WEST SUSSEX COUNTY COUNCIL
INFRASTRUCTURE CONSULTATIONDATE: 6th January 2008FROM: Ian Gledhill TO: Arun District Council
FAO: James Smith

SUBJECT: AB/147/08/ - COU from shop (A1) to domestic garage (C3)

70a, Tarrant Street, Arundel, West Sussex, BN18 9DN

BLOCK PLAN

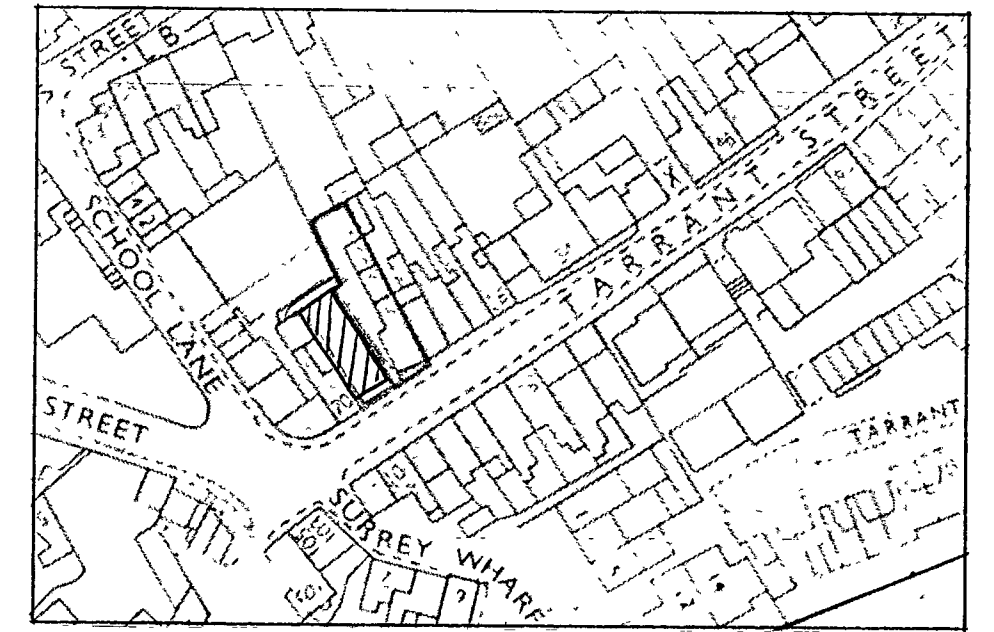
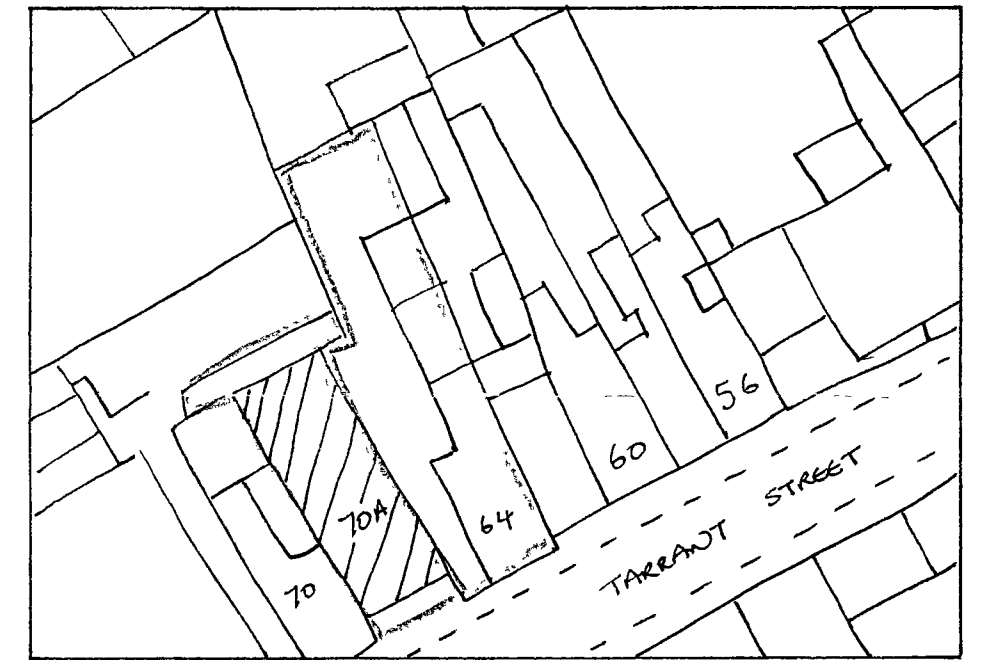
The existing site has a vehicular access onto Tarrant Street, which is one way (east to west) in this location. Traffic will therefore only be approaching the site from the east. Visibility is very restricted due to the frontages of the adjoining buildings. The existing parking arrangements are somewhat cramped allowing for one vehicle to park parallel to the existing building; the constraints of the parking area are such that a vehicle could not park perpendicular to the building without overhanging the carriageway, hence this restricts how vehicles can park. Given that vehicles are parked parallel they should not need to reverse onto the highway.

Notwithstanding the fact that there is an existing vehicular access, parking is presently only available for a single vehicle, which would signify a relatively low usage. Should the building be converted to a garage up to four spaces would be available, which raises concerns regarding the intensification of use of the access where visibility is very restricted. Whilst the Applicant states that the vehicles will reverse from the highway into the garage, there is no reasonable or enforceable condition that could be applied to ensure this takes place and there is no space for turning within the site.

Whilst mindful of the existing access and use of the site, the proposals would potentially constitute an intensification of use of the access and result in further reversing movements in a location where visibility is restricted. An objection would therefore be raised for the following reasons.
